From:
To: [RichardA Gilbert](#)
Cc: [DCAdmin](#);
Subject: Application number 2021/94552
Date: 16 March 2022 14:31:23

Application Number: 2021/94552

**Kirklees Council planning application 2021/62/94552/E
Land at Barnsley Road, Denby Dale, Huddersfield, HD8 8TS**

HIGHWAY DESIGN ISSUES PLANNING APPLICATION REF

BARNESLEY ROAD : DENBY DALE | SITE LAYOUT

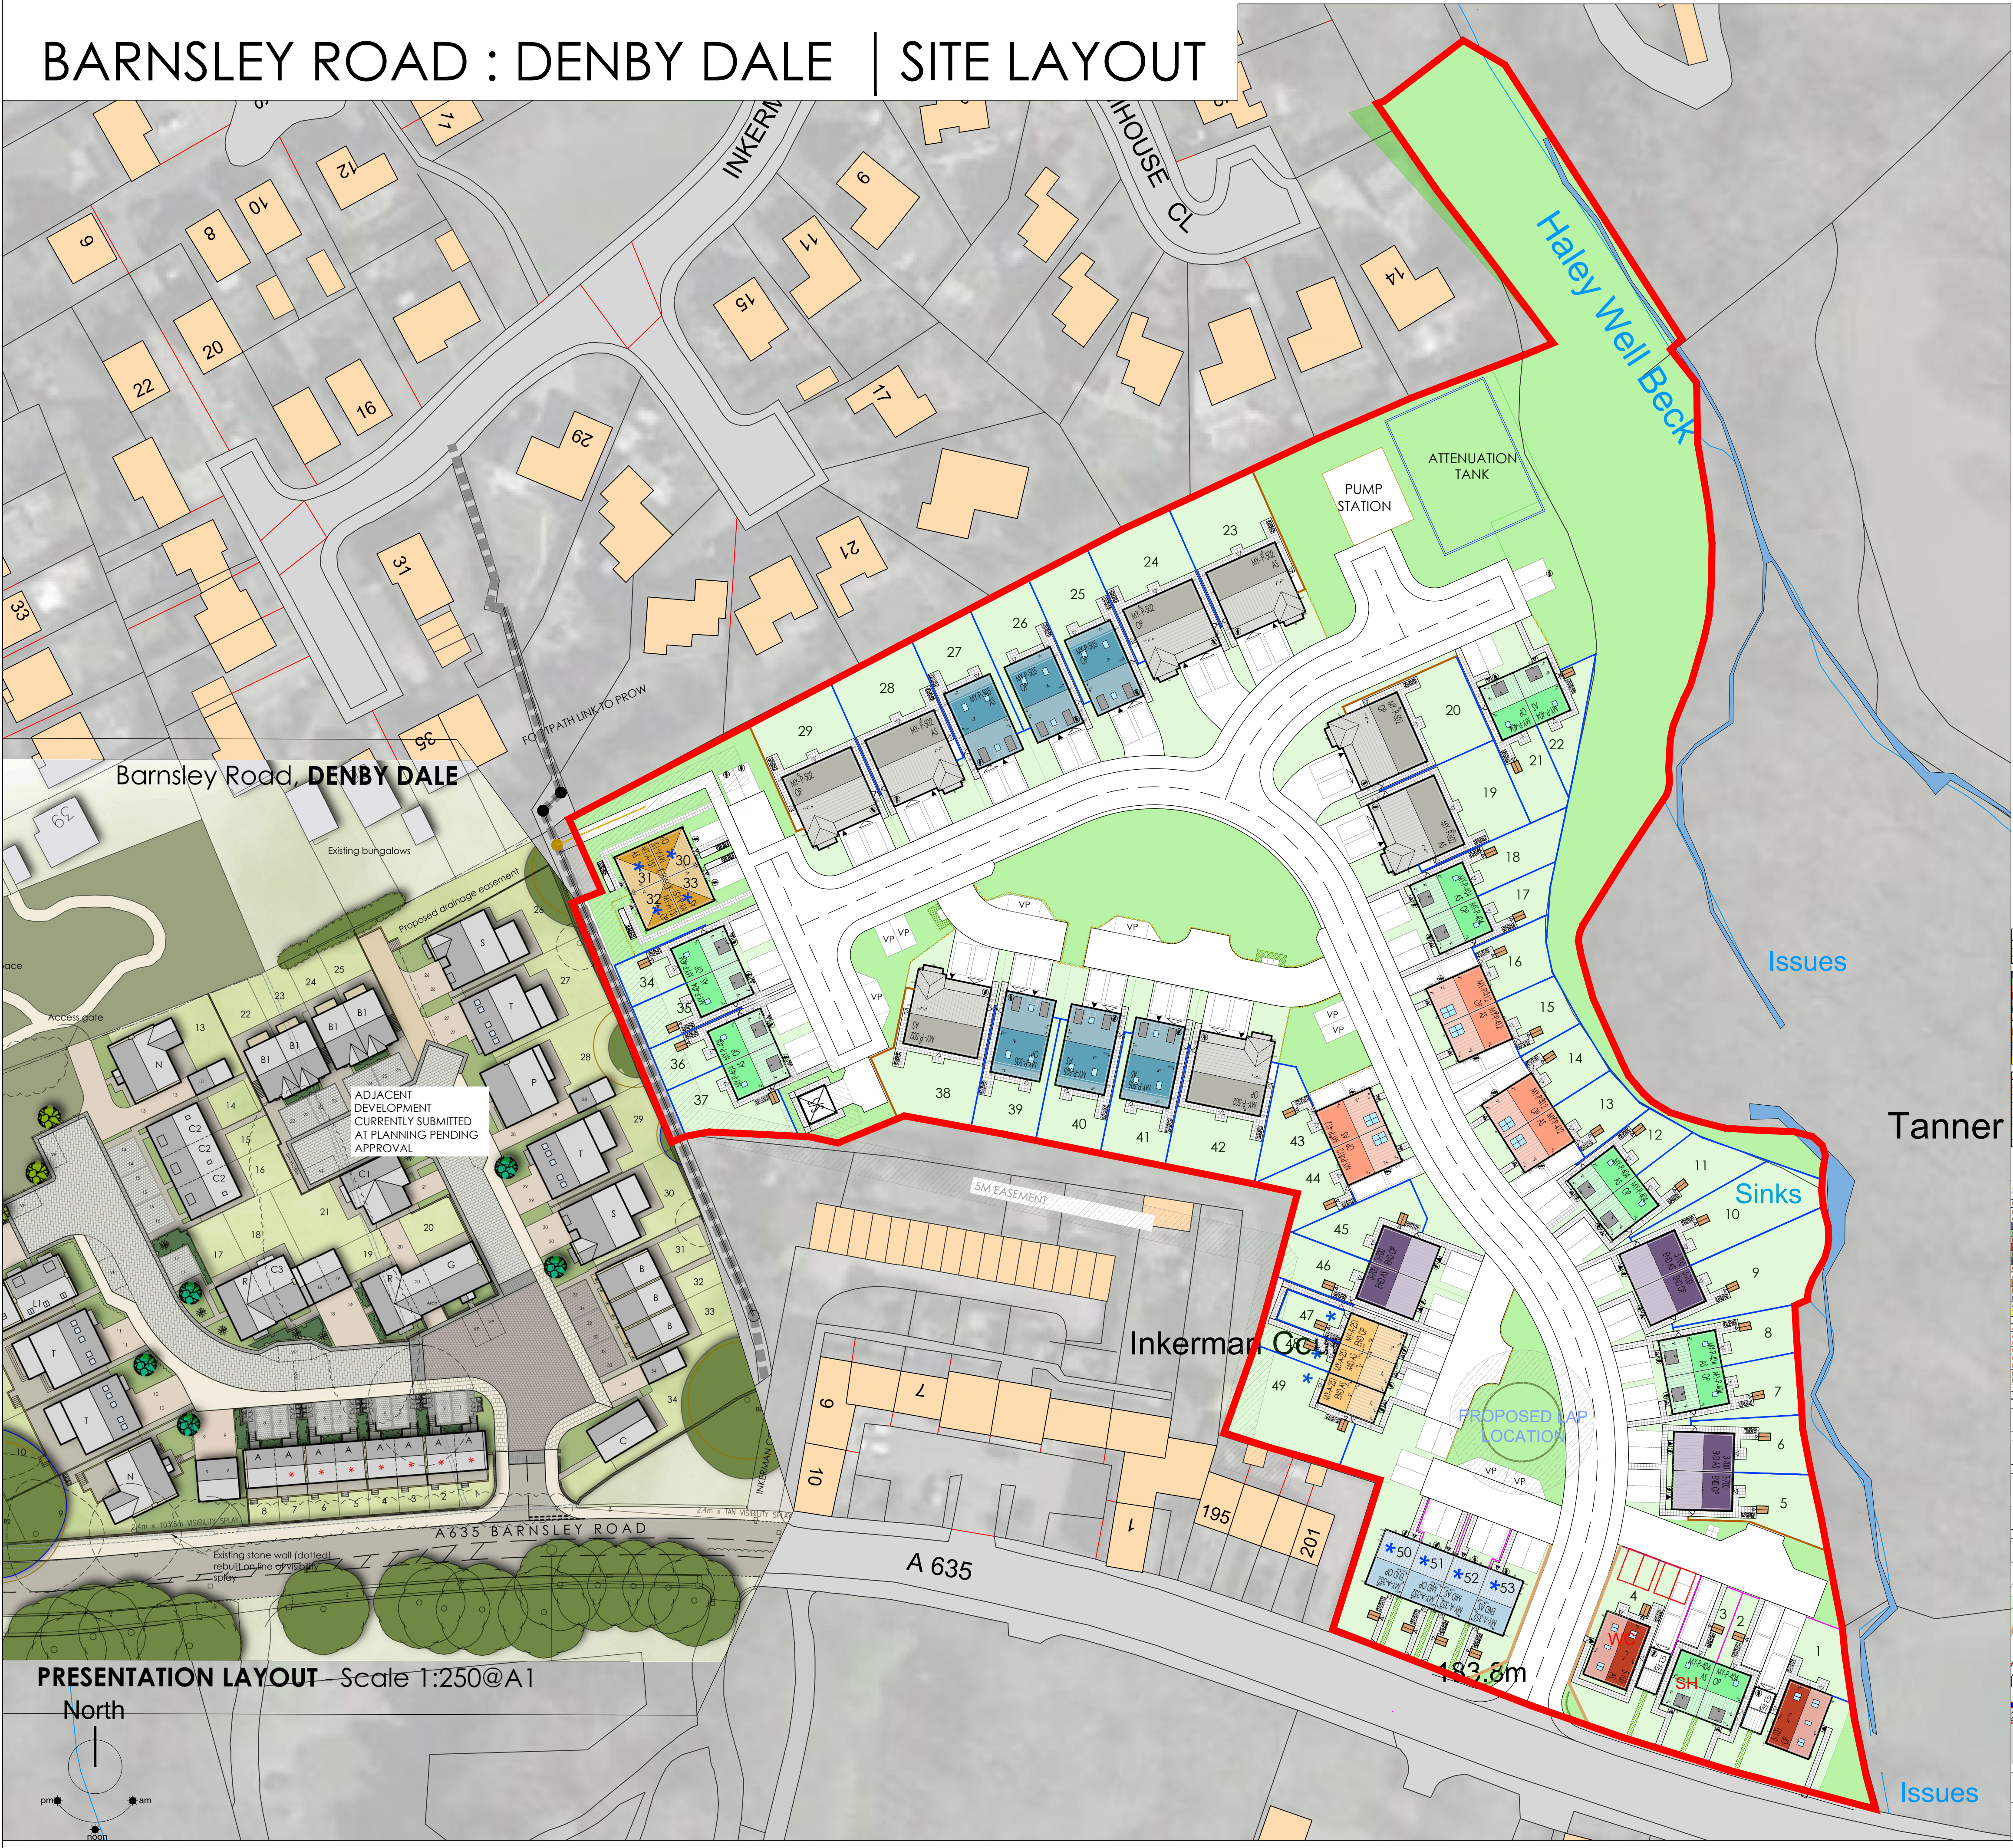
The Jones Tool Co SSAS currently owns land WYK2560 adjacent to the proposal which is currently not land locked. We are concerned that under this development the land on the north side of Barnsley Road behind Inkerman Court is in danger of becoming land locked. The access to this land under this proposal appears to disappear. (Shown on attachment B1 plot 50) The current access seems to have been blocked. (See attachment D)

The land South of Barnsley Road WYK2560 with access from the main road has an extremely dangerous entrance (blind corner) as it stands at this moment in time. Access to this land is required by Northern Power Grid periodically so they can inspect mains pole Inkerman Mill 186. The proposed development of plot 50 to 53 along the north side of Barnsley Road will further restrict the sight line of the entrance of WYK2560 (see attachment E)

It would appear from the application submitted the access to our clients' land has been blocked by the form of a padlocked wooden gate. Our client confirms that for 25 years this access has never had any form of gate and has been used as a path/access without restriction or hindrance.

Please confirm that your client's planning application will not involve any development of our client's land and that access to that land will be preserved. Our client needs vehicular access to his land at least 3 metres wide.
